OXFORDSHIRE COUNTY COUNCIL'S RESPONSE TO CONSULTATION ON THE FOLLOWING DEVELOPMENT PROPOSAL

Application no: 22/02866/OUT

Proposal: OUTLINE planning application for up to 120 dwellings, vehicular and pedestrian access off Ploughley Road, new pedestrian access to West Hawthorn Road, surface water drainage, foul water drainage, landscaping, public open space, biodiversity and associated infrastructure. Access off Ploughley Road is not reserved for future consideration

Location: Land East Of, Ploughley Road, Ambrosden

Project	Originator	Volume	Level	Type	Role	Orig No.
B05927	CLK	XX	XX	DR	C	0007
Scale	1/250 & 1/100 @ A1	Date	20.07.2022	Revision	P05

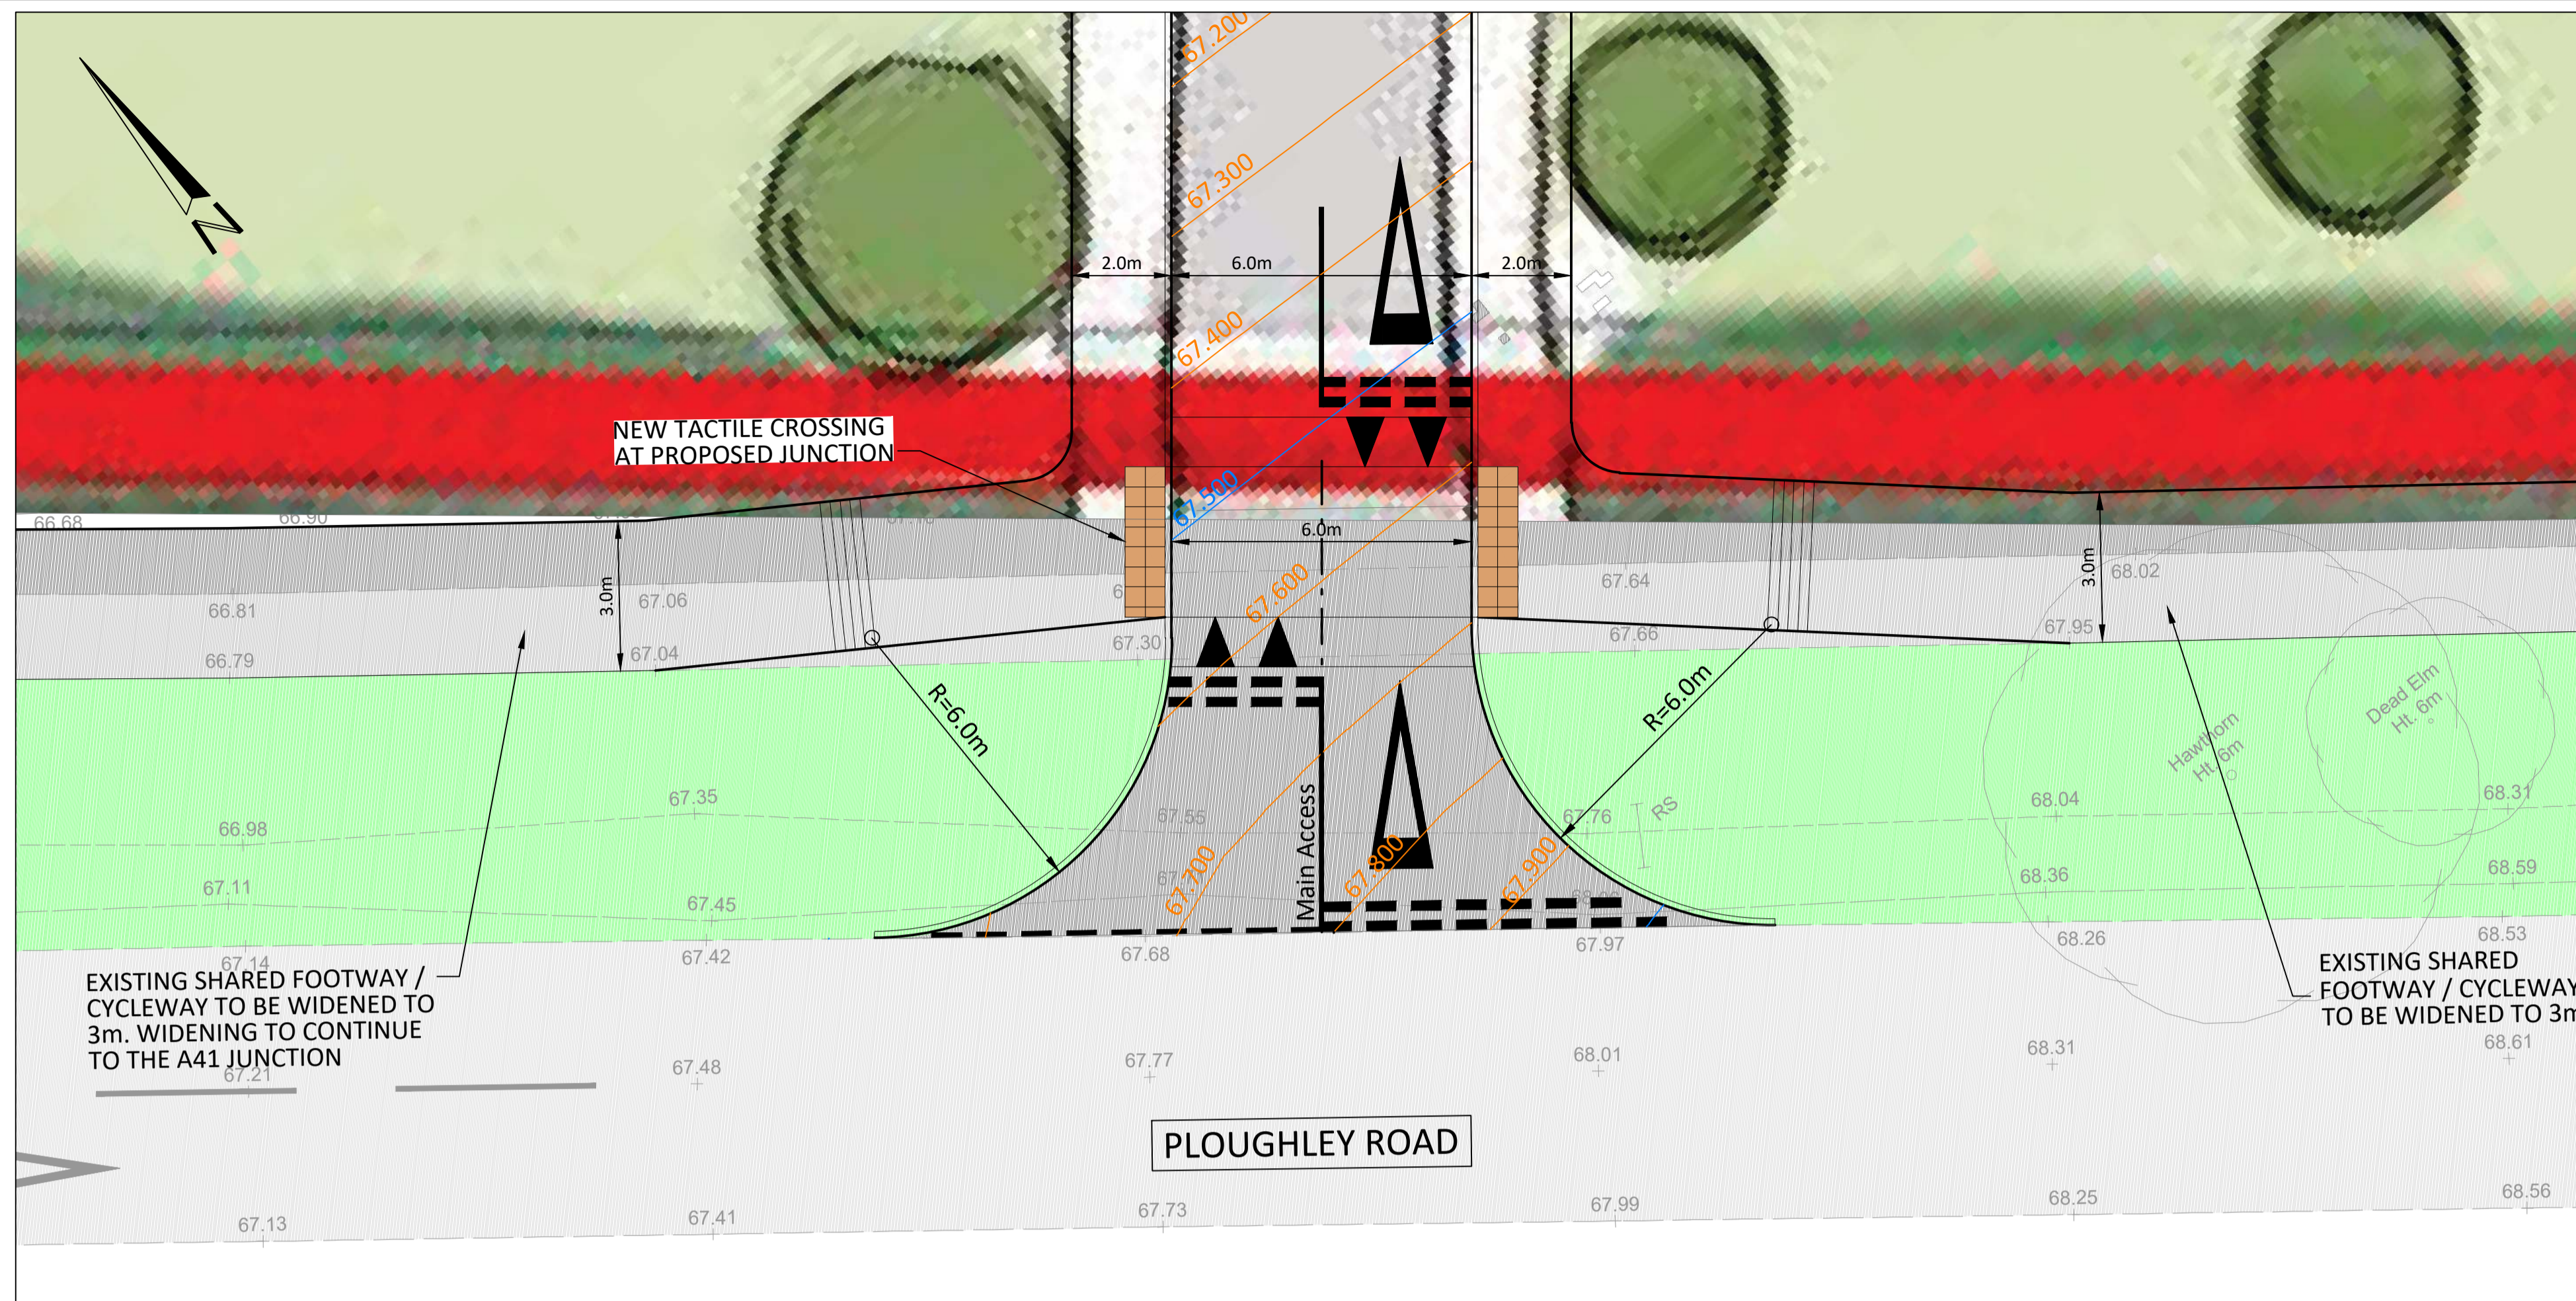
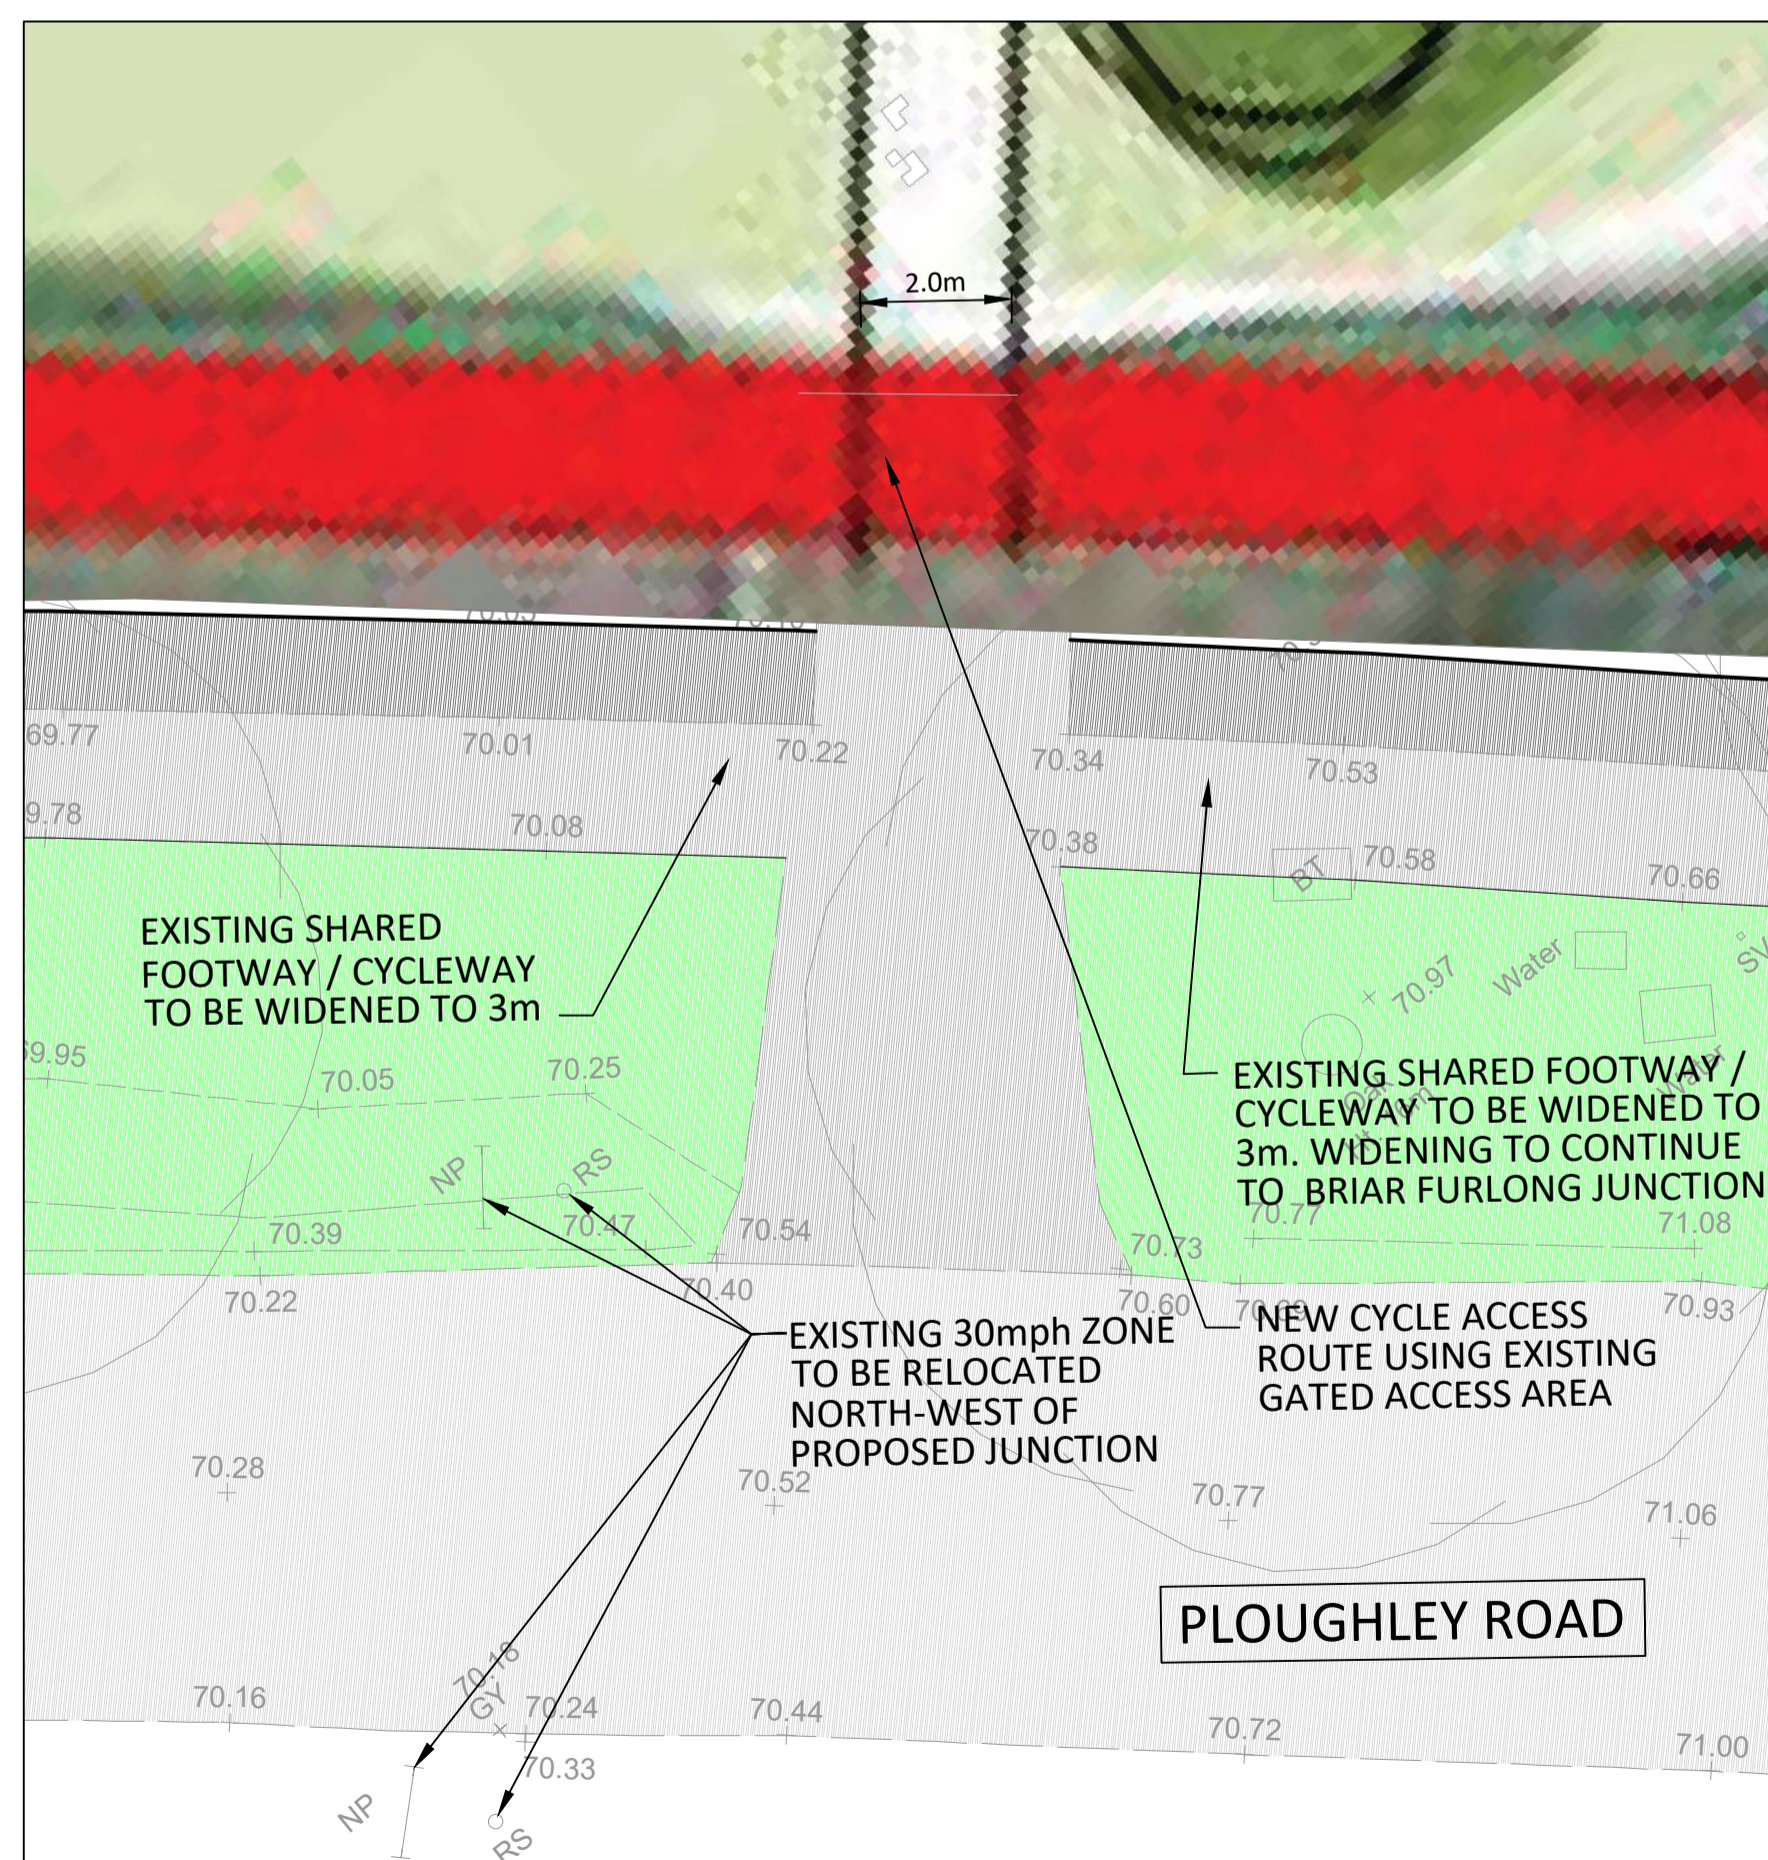
- A new site access bellmouth junction on Ploughley Road (as shown indicatively on Clarkebond drawing B05927-CLK-XX-XX-DR-C-0007 Rev. P06).
- Relocation of the speed limit signs, village gateway and “dragon’s teeth” road markings, including public consultation and TRO (as shown indicatively on Clarkebond drawing B05927-CLK-XX-XX-DR-C-0012 Rev. P02).

- Widening of the cycletrack beside Ploughley Road to 3.0m (where practical to do so) between the A41 and Briar Furlong (as shown indicatively on Clarkebond drawing B05927-CLK-XX-XX-DR-C-0007 Rev. P06).
